RE: Community Meeting Report for  
Rezoning Petition #2008-033  
Park Road Retail Project. Site Plan Amendment and  
Rezoning Request  
Petitioner: Pacific Southern Development, LLC

**2/5/08  
SUMMARY MINUTES  
FOR  
COMMUNITY MEETING  
FOR PETITION #2008-033  
PARK ROAD/ HEATHER LANE CONDITIONAL REZONING  
PETITIONER: PACIFIC SOUTHERN DEVELOPMENT, LLC  
Held On Tuesday, January 29, 2008 at 7:00 PM – 8:30 PM**

**PRELIMINARY
SITE PLAN**

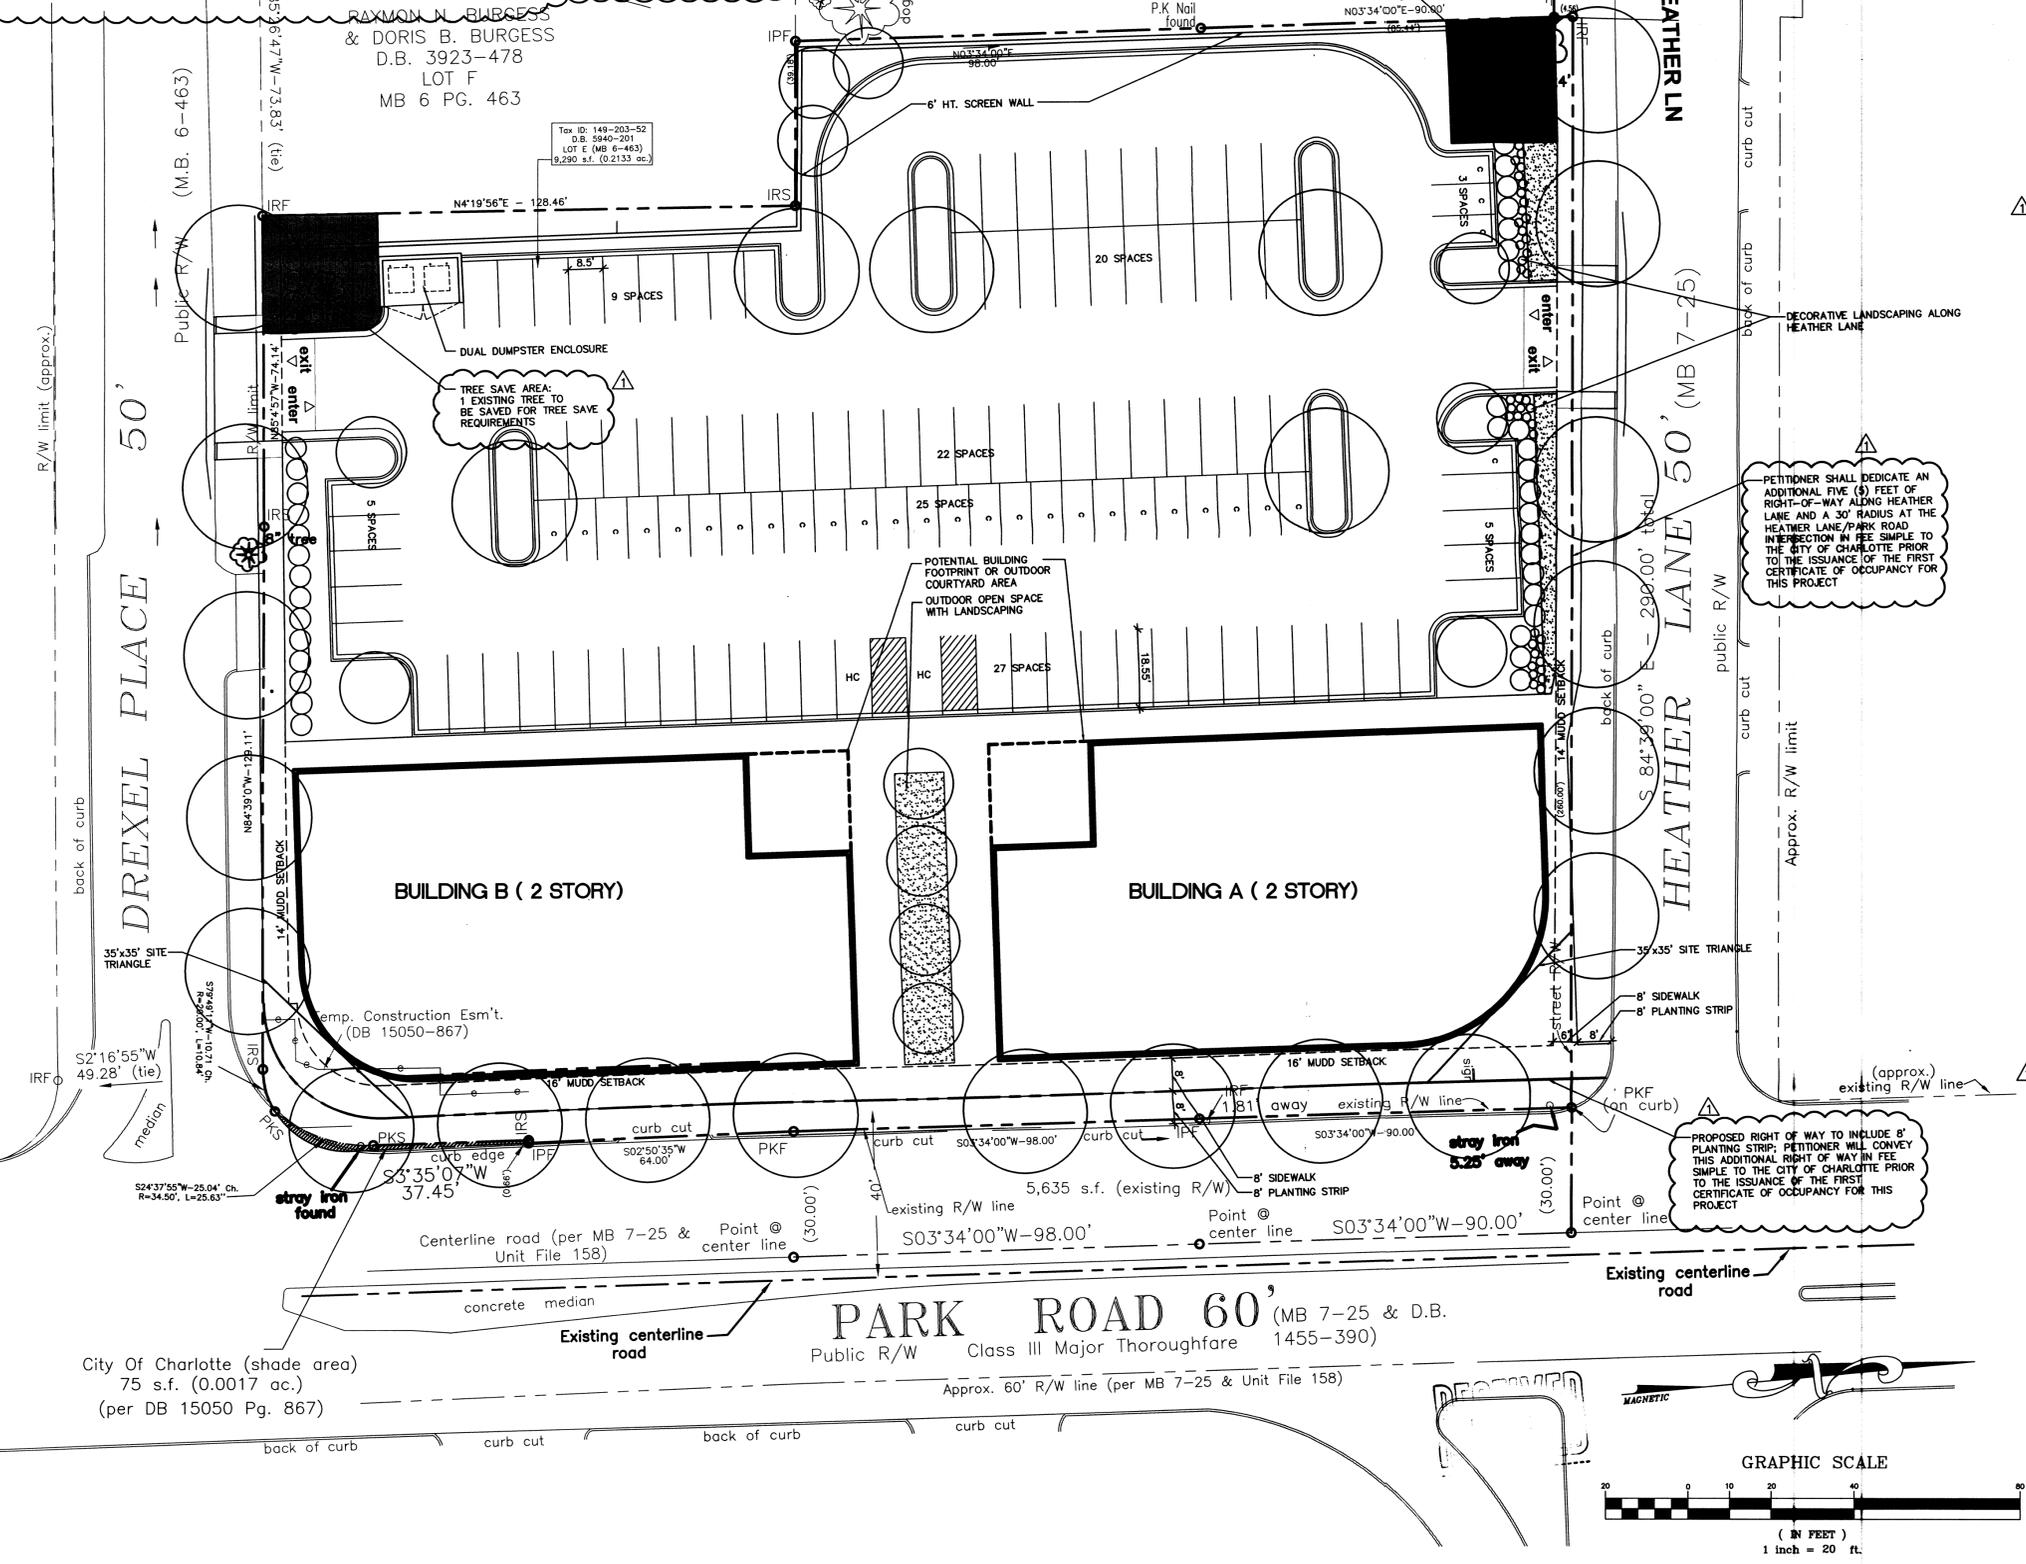
8. Will the wall be continuous?

9. Will the developer be willing to increase the height of the 6' ht. wall?

14. There was concern of traffic along Park Road and the "pork chop" intersection at Drexel Place. An attendee expressed concern over placement of the pork chop intersection indicating the desire to be able to make a left turn off Drexel Place.

19. Where will the dumpster be located? Several attendees suggested relocating the dumpster or possibly making the wall higher than 6' at its location.

21. Where exactly will the buffer wall be located? Is there a side yard requirement?

**Yes. The wall will be continuous along the perimeter of the rear property line.**

**The screen wall will be built to code requirements.**

**The pork chop intersection is enforced per the Charlotte Department of Transportation(CDOT). However, after construction of the project, CDOT will conduct traffic studies to evaluate the need for any additional traffic control measures.**

**The dumpster will be located off the Drexel Place entrance for ease of the dumpster service vehicle.**

**The wall will be located approximately 3' from the rear property line. There is no side yard requirement for this zoning.**
